June 8, 2015

**Re: IL Vicino Canteen Brewhouse Kitchen Expansion
2381 Aztec Rd NE
Traffic Circulation Layout
Engineer's/Architect's Stamp dated 6-5-15 (G16-D089)**

Re: IL Vicino Canteen Brewhouse Kitchen Expansion
2381 Aztec Rd NE
Traffic Circulation Layout
Engineer's/Architect's Stamp dated 5-11-15 (G16-D089)

Based upon the information provided in your submittal received 5-13-15, the above referenced plan cannot be approved for Building Permit until the following comments are addressed:

2 Existing Site Conditions

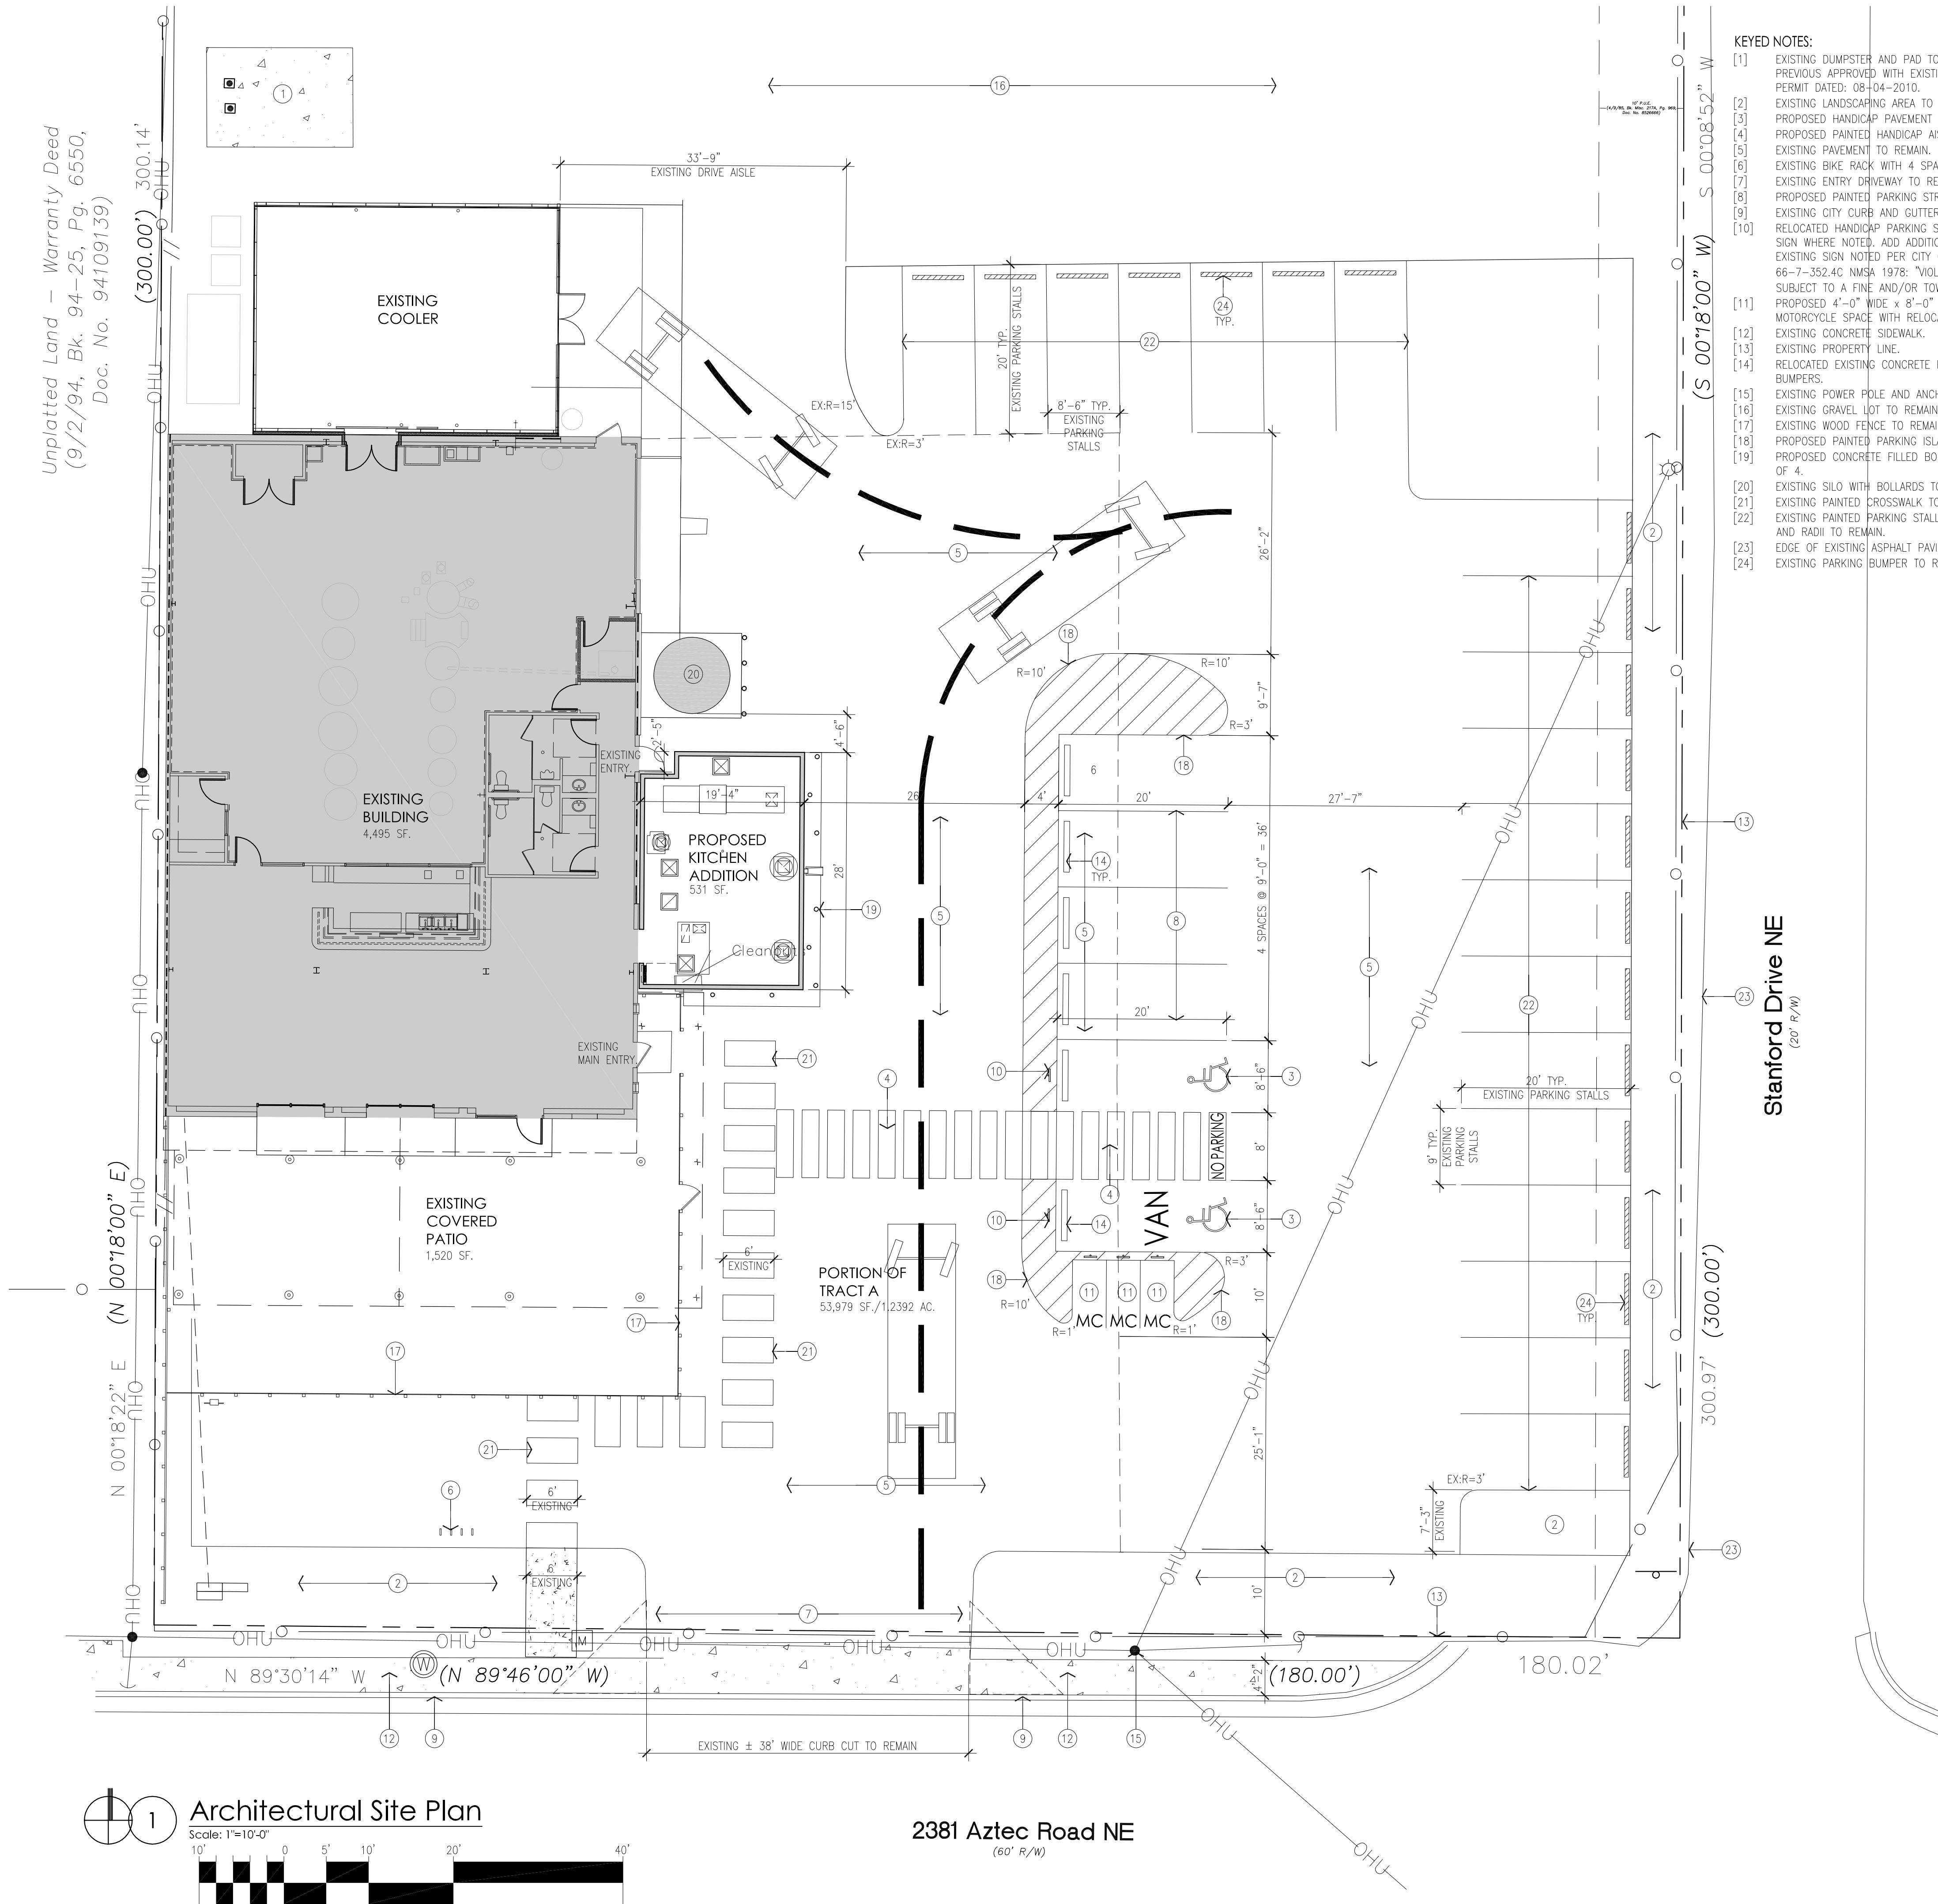
1. Please identify and dimension all existing pedestrian walkways from the public R.O.W. and from the existing parking lot. Dimension the width of the public R.O.W. sidewalk.

2. Please identify and dimension lot and all existing parking spaces in the "Additional Parking Area".
3. Please clearly dimension the drive aisle between the proposed kitchen addition and the handicap parking area. Per the DPM, the drive aisle must be a minimum of 24 ft. wide.

4. The ADA van accessible sign must have the required language per 66-7-352.4C NMSA 1978 **"Violators Are Subject to a Fine and/or Towing."** Please provide a detail of this sign. Please provide detail on drawing. Please ensure that these signs are placed in the proposed painted parking island.

5. Per the DPM, a 6 ft. wide ADA accessible pedestrian pathway is required from the public sidewalk to the building entrances. Please clearly show and dimension this pathway Note 21.

6. Per the DPM, a 6 ft. wide ADA accessible pedestrian pathway is required from the HC parking stall access aisles to the building entrances. Please label and dimension pathway Note 3.

7. Provide a min 6" or max 8" high concrete barrier curb or other acceptable barrier between landscaping and parking areas and/or drive aisles. Provide parking bumpers west of handicap parking spaces along the driving isle to

provide protection for the handicap signage. Please provide parking lot details of the "Additional Parking Area".

8. Design delivery vehicle route needs to be shown.
9. Service vehicle and/or refuse vehicle maneuvering must be contained on-site; provide a copy of refuse approval (if applicable).
10. Please provide a sight distance exhibit for the entrance on Aztec Rd. (see the *Development Process Manual, Chapter 23, Section 3, Part D.5 Intersection Sight Distance*).

11. Please add the following note to the clear sight triangle: "Landscaping and signage will not interfere with clear sight requirements. Therefore, signs, walls, trees, and shrubbery between 3 and 8 feet tall (as measured from the gutter pan) will not be acceptable in this area."
12. Please specify the City Standard Drawing Number when applicable.
13. Please include two copies of the traffic circulation layout at the next submittal.
